June 10, 2015

**RE: Boca Negra Dam
Letter of Map Revision
AMAFCA**

Wilson & Company has reviewed the comments provided in a letter dated May 28, 2015 by the City of Albuquerque on the Boca Negra Dam LOMR. Below is a response to the comments:

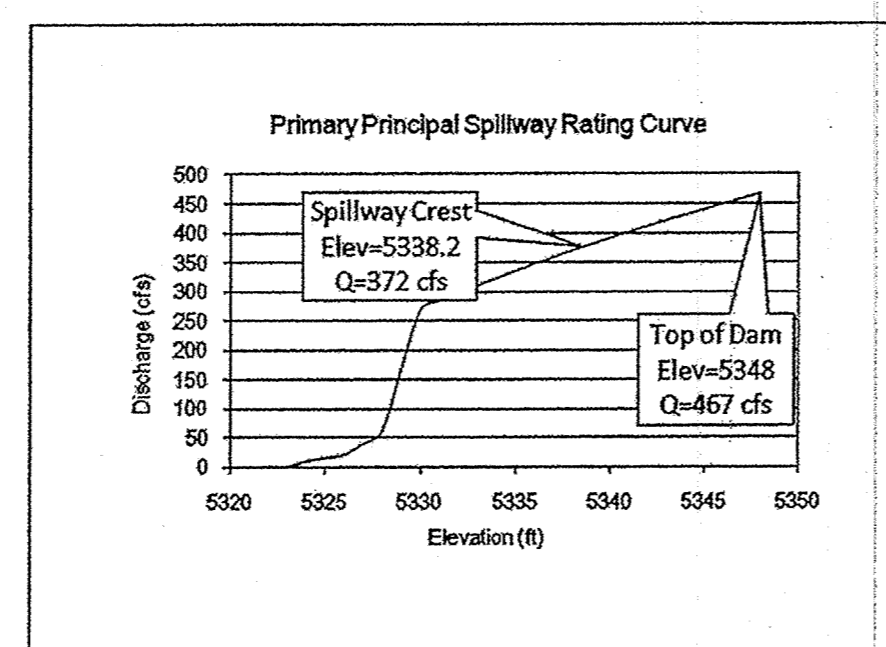
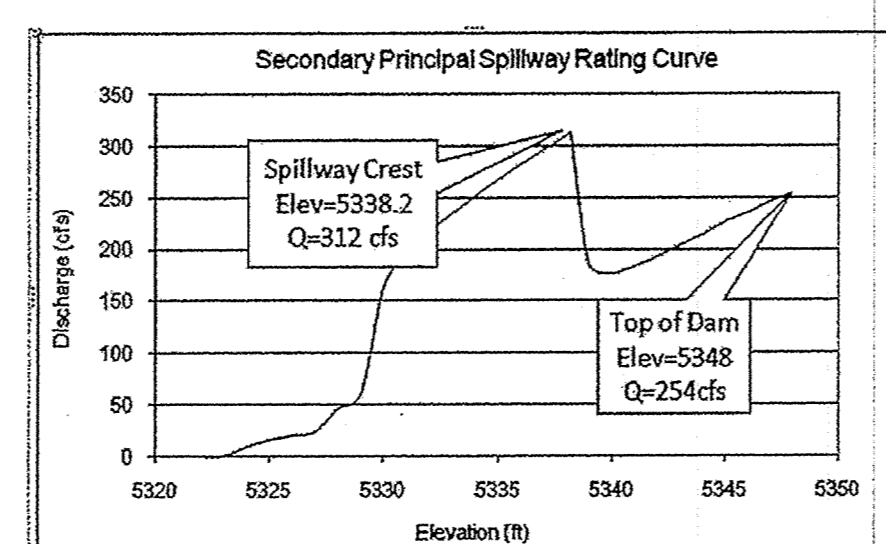
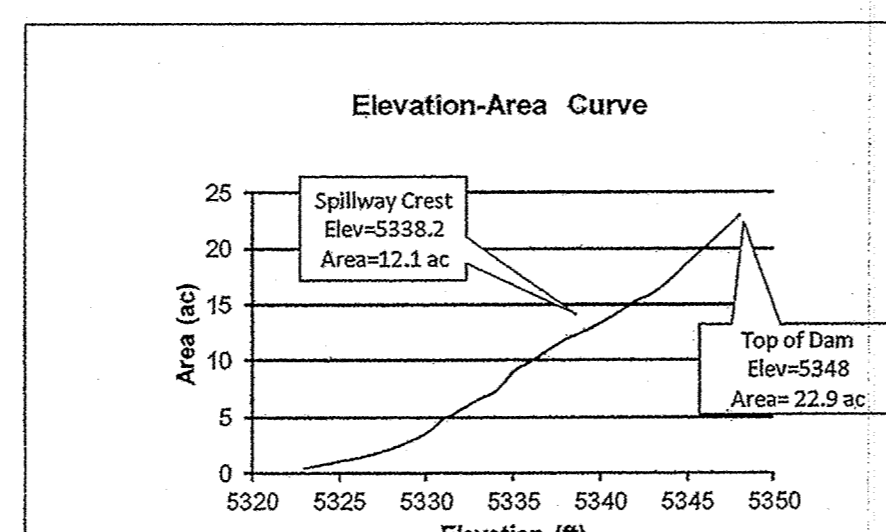
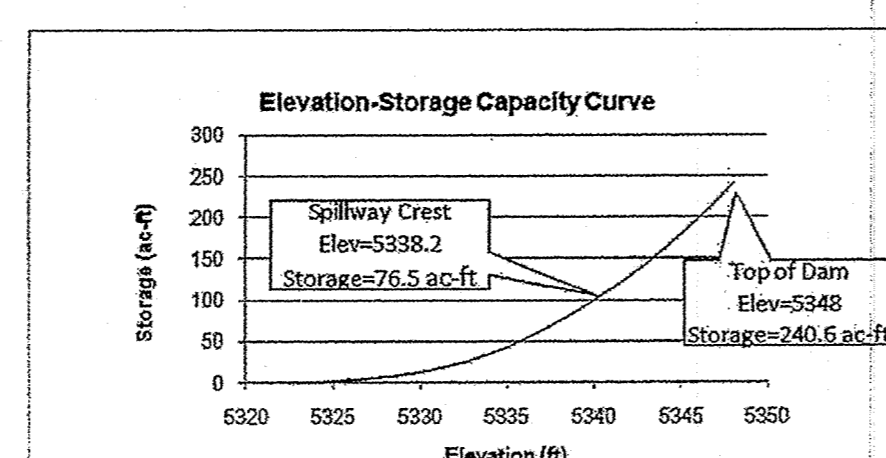
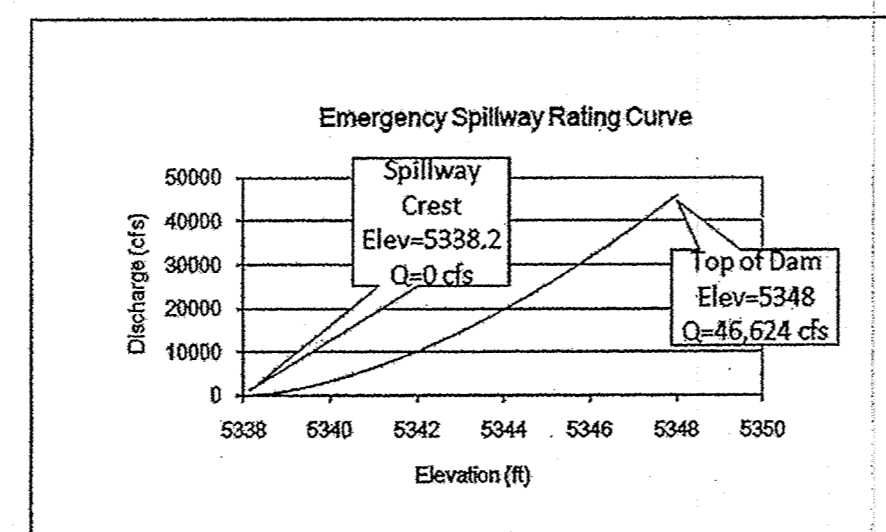
- Provide stage-discharge curves/tables for the dam for initial design and as-built condition and how were they calculated (orifice equation)?

The dam rating curve table has been provided in Appendix 3 on the Dam Cover Sheet, Sheet 1R of 62. A pdf of the rating curves for design and as-built conditions is attached.

ANNOTATED FIRM

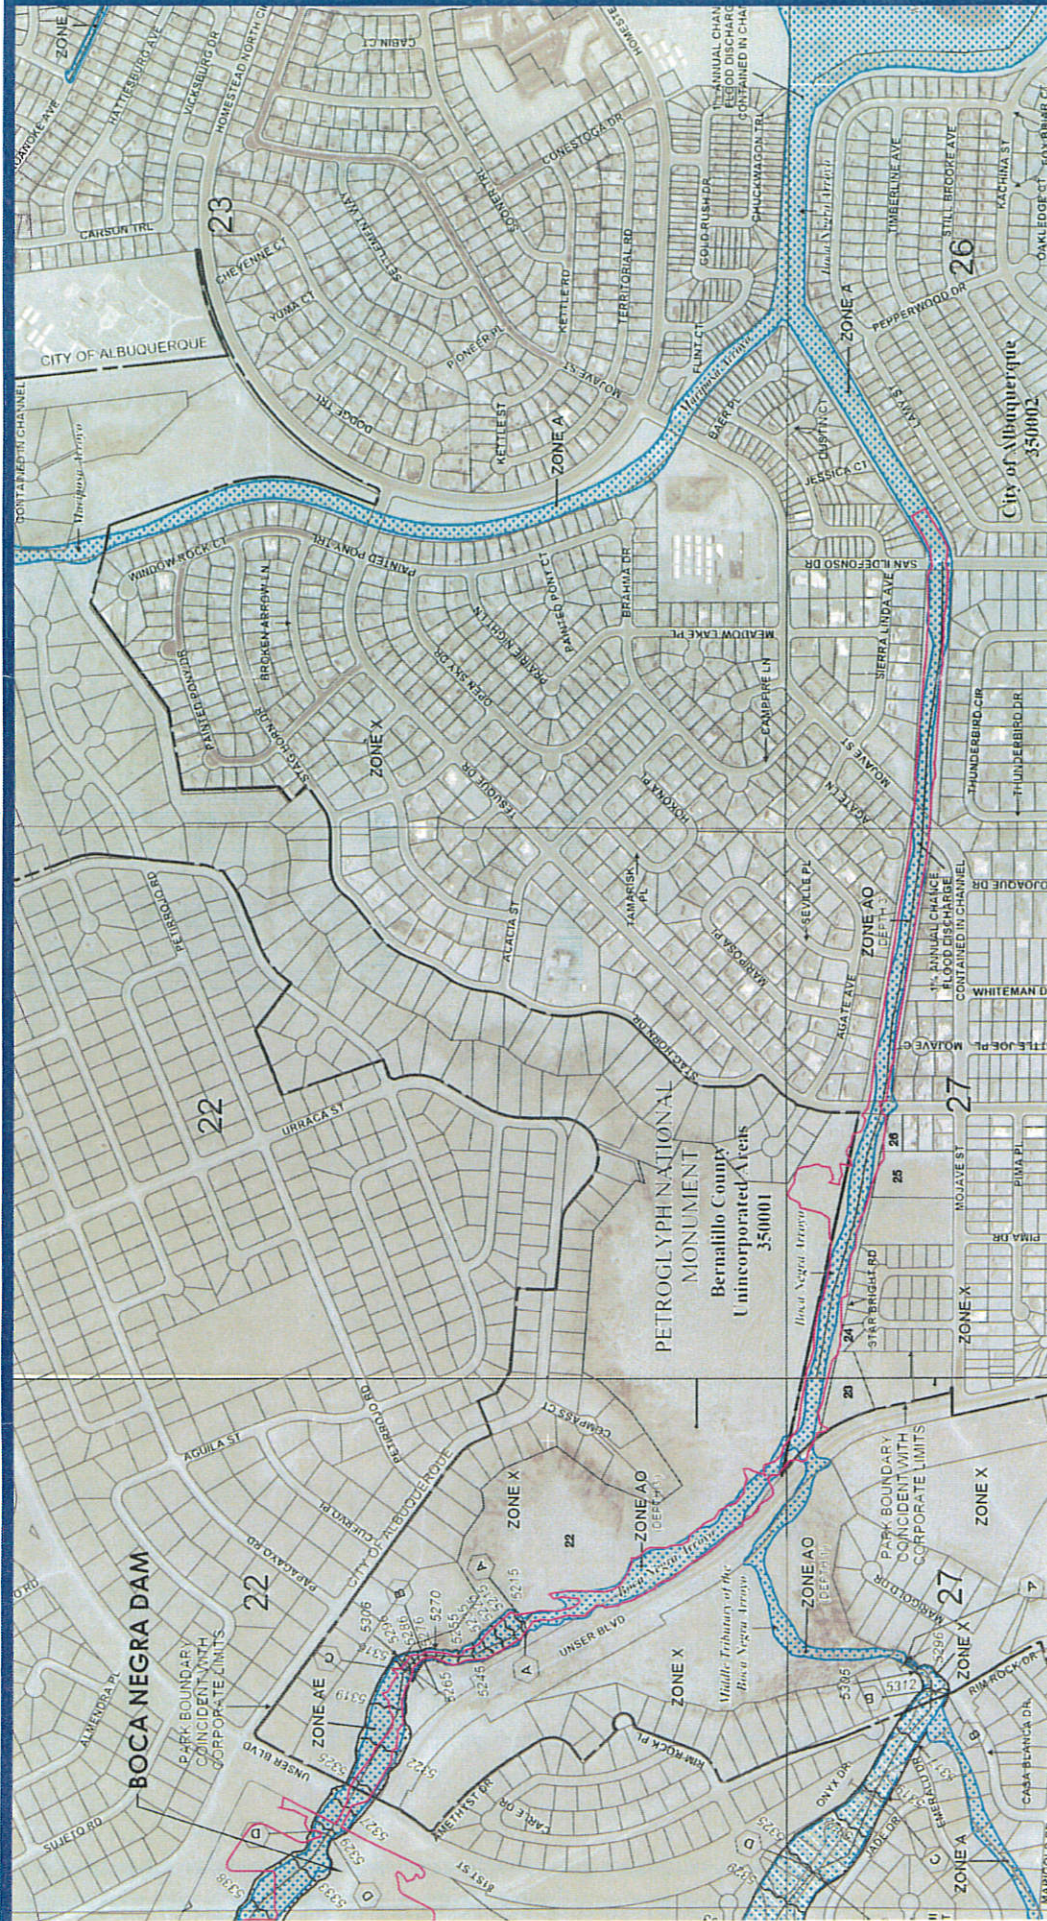
3. The annotated FIRMS are to be labeled "Annotated FIRM"

17. The Work Map and Annotated FIRM should reflect LOMR 09-06-2899P 3-25-10. The Flood Zone on Vista Vieja has been revised for 5 years.

This has been revised.

The maps have been updated to indicate the area affected by this LOMR.
